From: Andrew Fuller [REDACTED]
Sent: 05 March 2018 12:31
To: Anita Gardner
Cc: Juan Baeza; Martyn White; Nick Field; mv rowan; AFA
Subject: Re: Planning Consultation on: AB/149/17/L

**Listed Building Consent for Alterations, Extension or Demolition of a Listed Building
APPLICATION AB/149/17/L**

Site Address: 44 Tarrant Street Arundel BN18 9DN

Description of Works: Listed building consent for internal alterations & renovations

Drawing No
171164/ 105

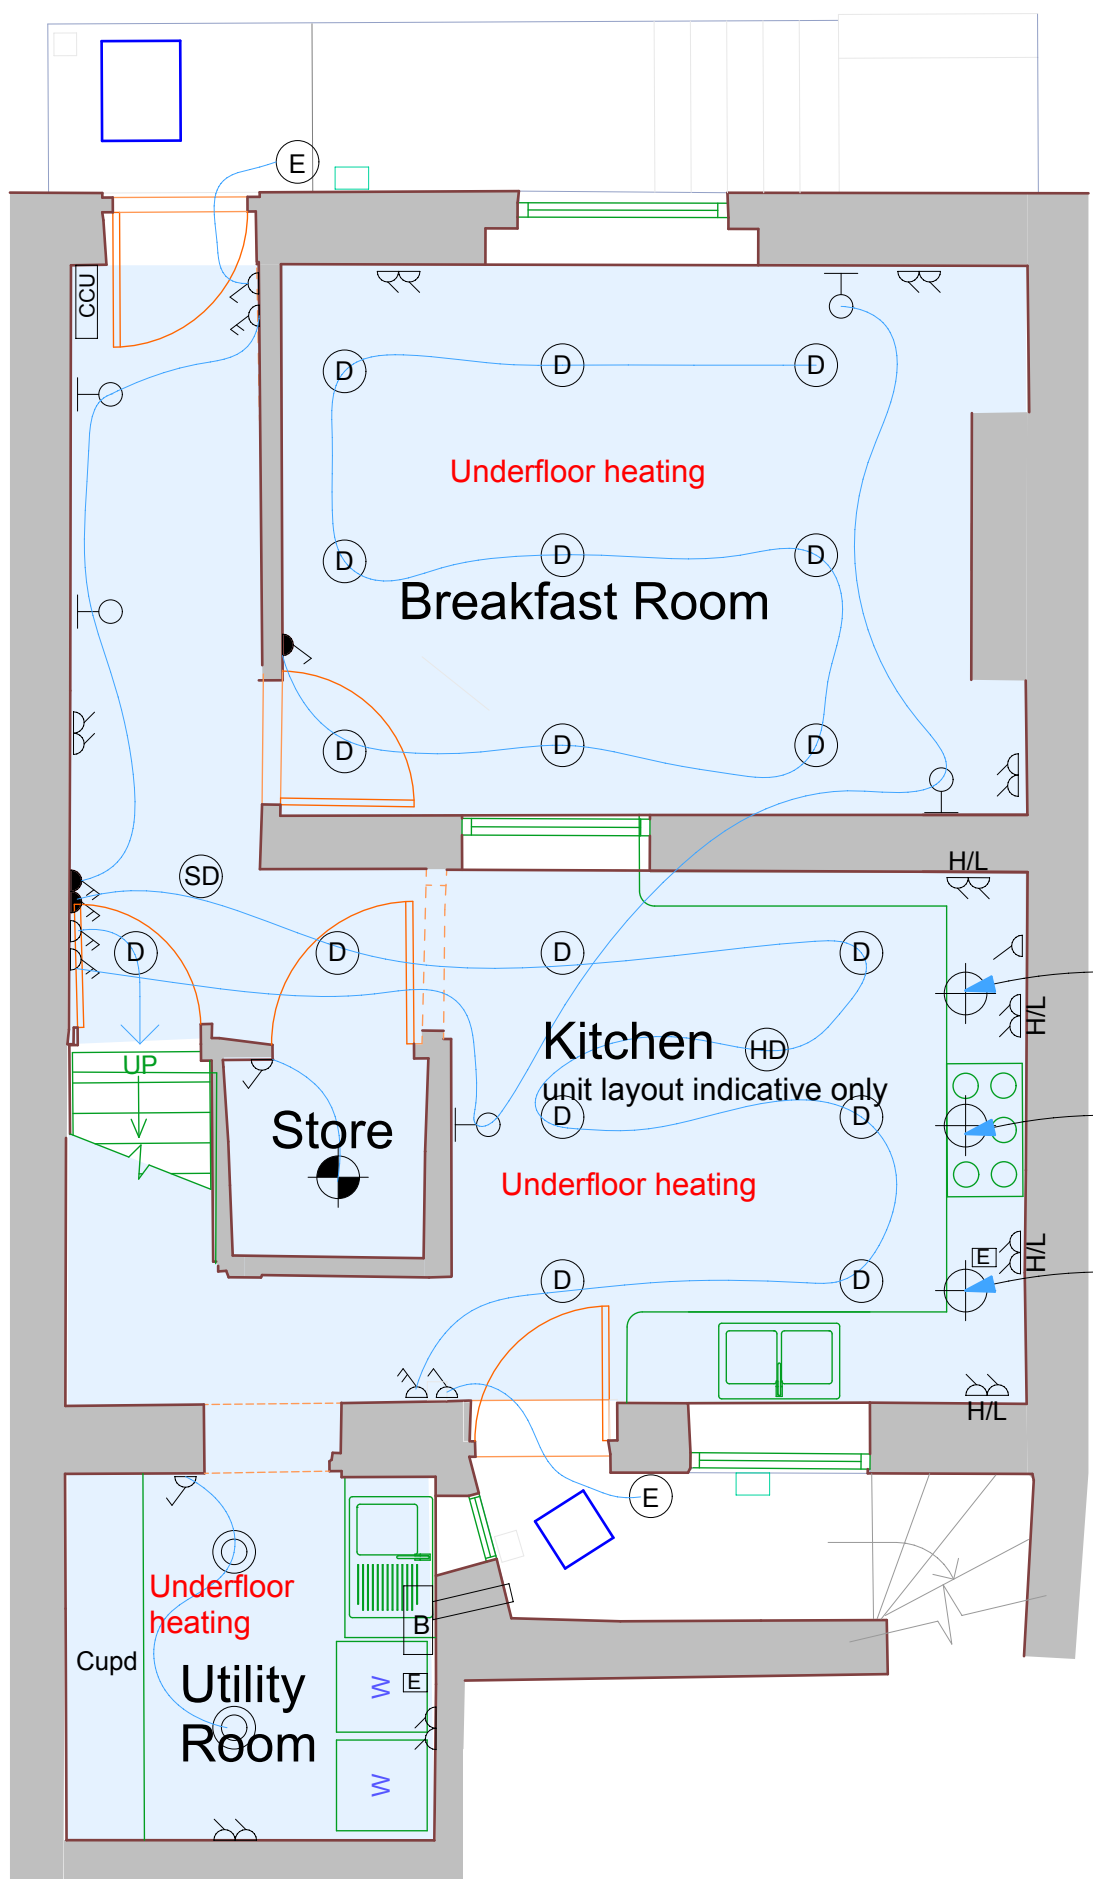
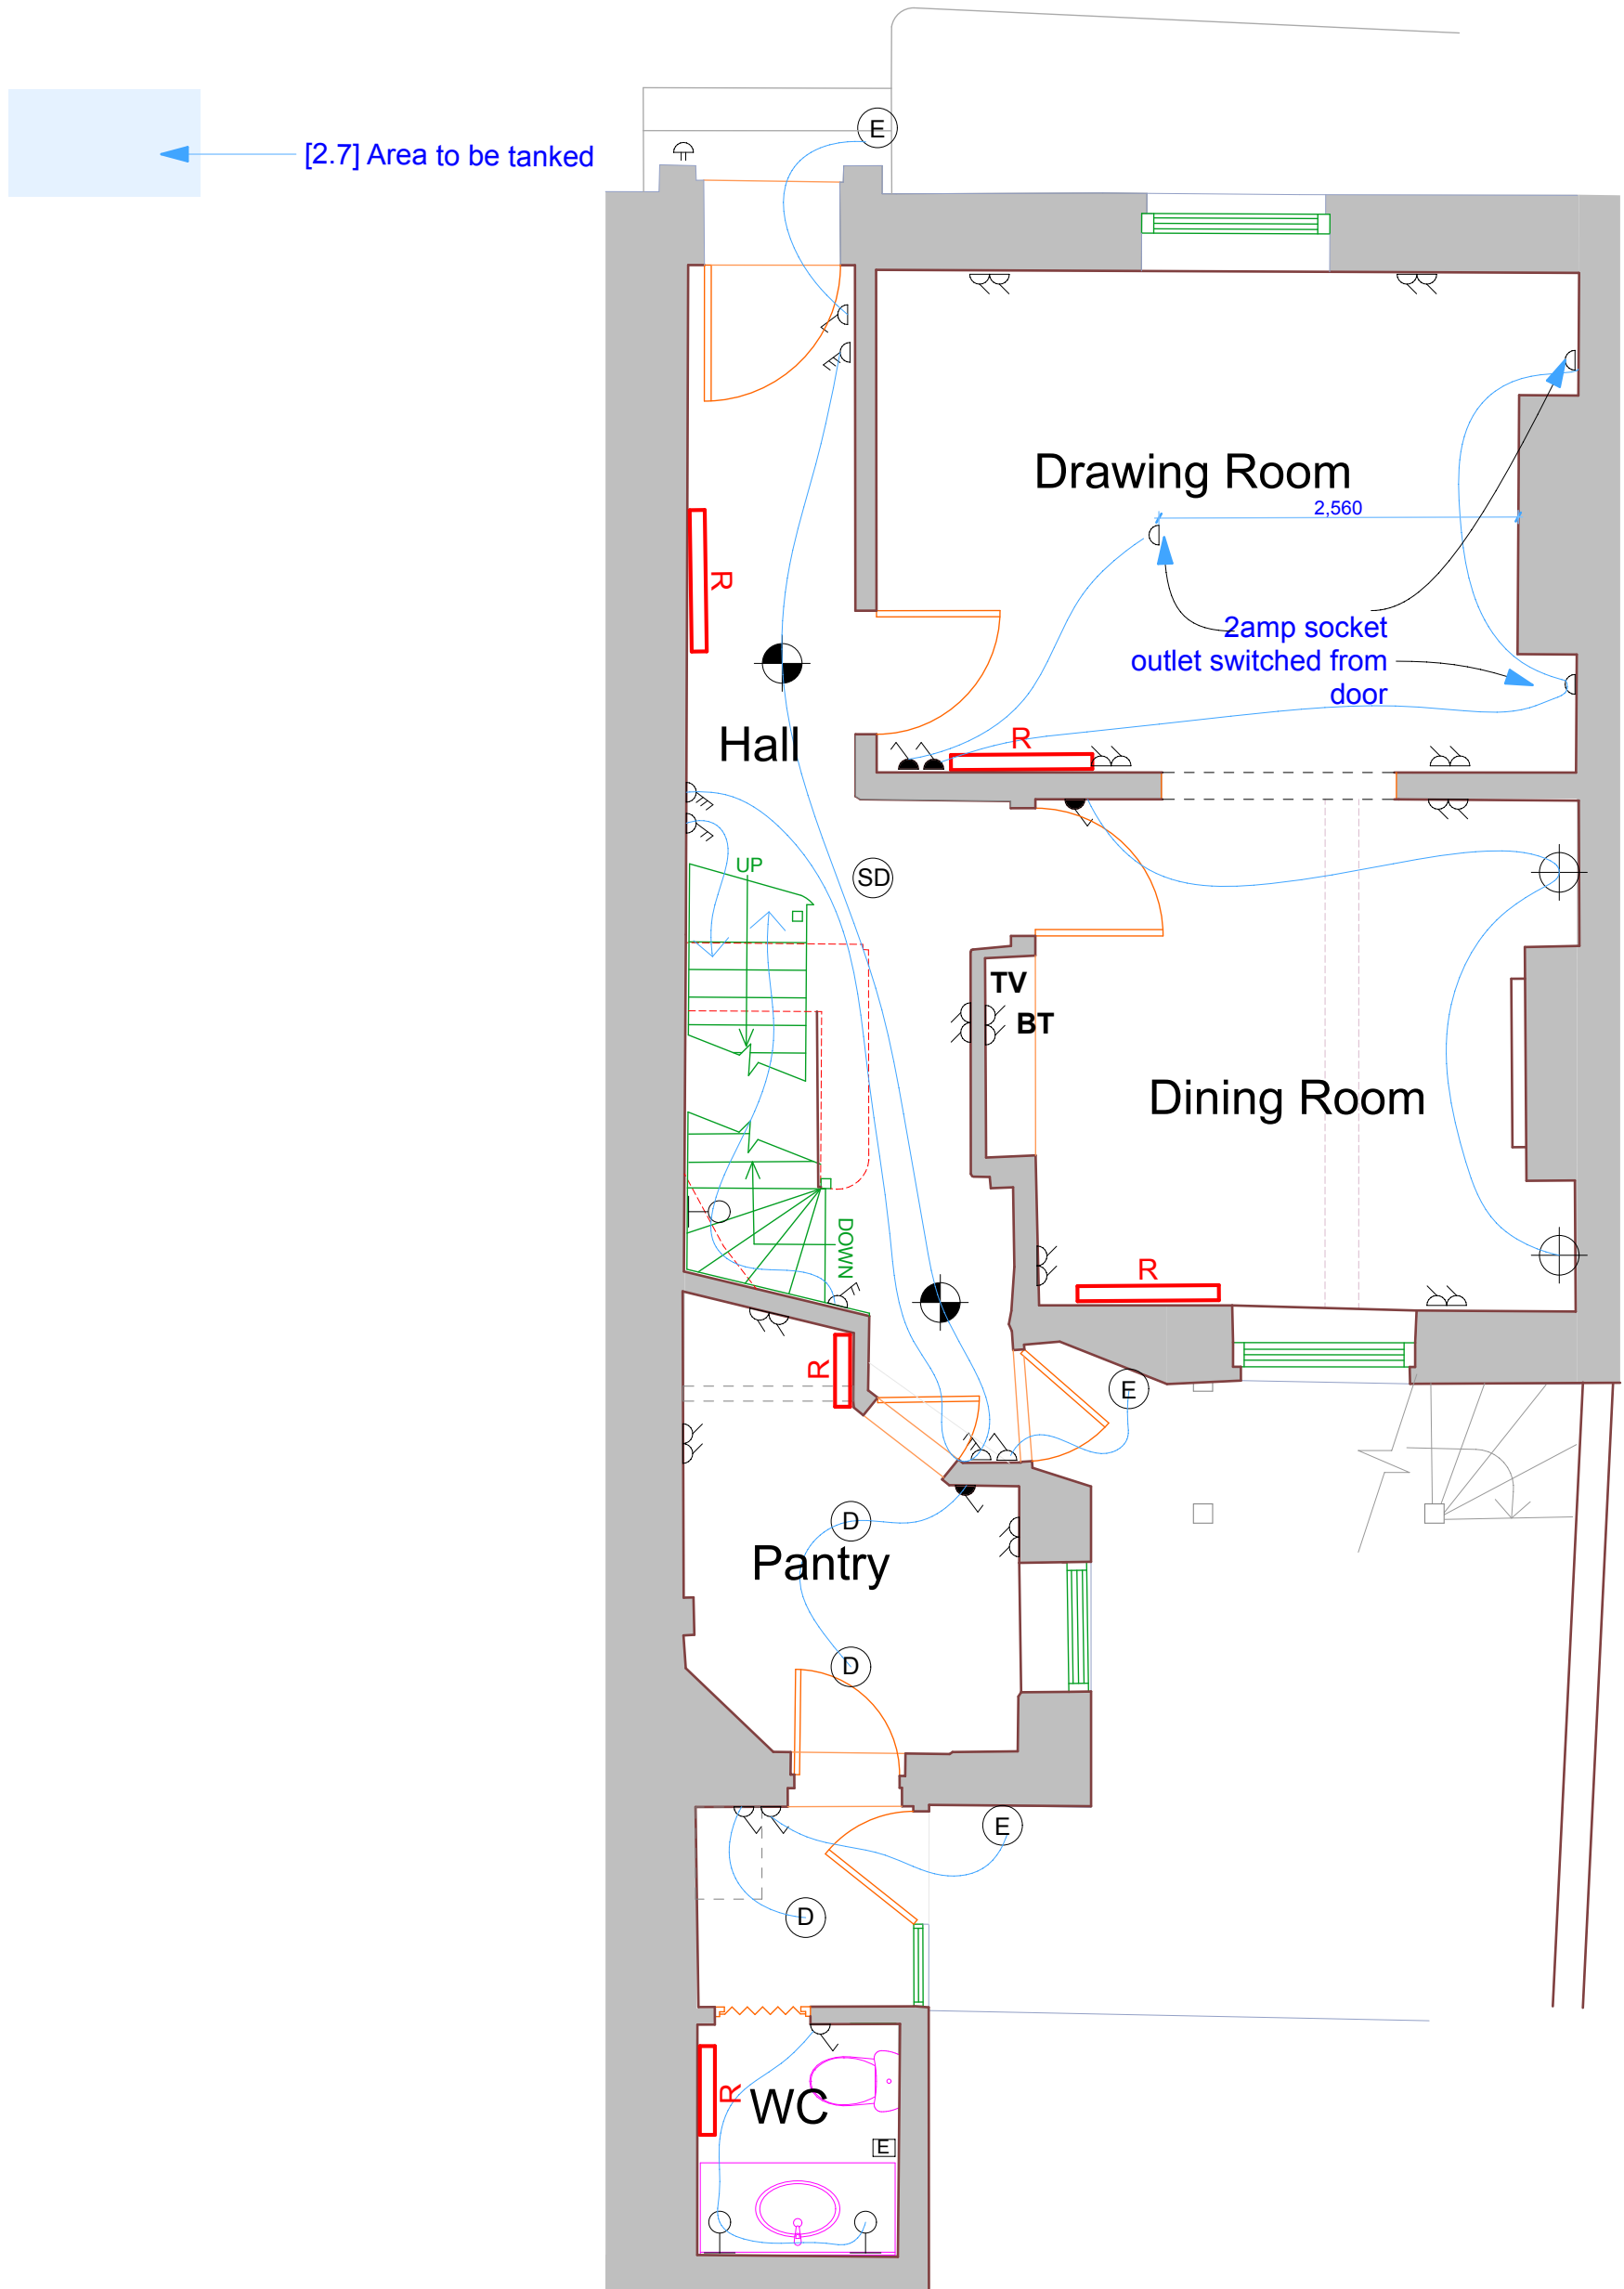
- The installation of downlighters other than to 2nd Floor where dropped ceiling is evident. The introduction of these is disruptive to historic fabric.

- New radiators may be fitted in identical locations, using existing pipework (no changes are specified).

The Building Regs Heating and Lighting drawing has been provided at the Planning submission stage, in order to demonstrate the intended positioning of downlighters only in the ceilings with which we are in agreement. There is a small contractor error which will be repaired. It was noted that fire alarm supply wires in the corridor were mistaken at inspection by the LPA to be d/lighters.

The Heating/Electrical drawings provided demonstrate the minimal re-positioning of radiators in 2 rooms. These have no consequence to the fabric of the building and this condition is deemed unacceptable. The re-positioning is intended to provide more efficient warm air circulation, next to windows, and are fixed to the floor only (Cast-iron replacements)
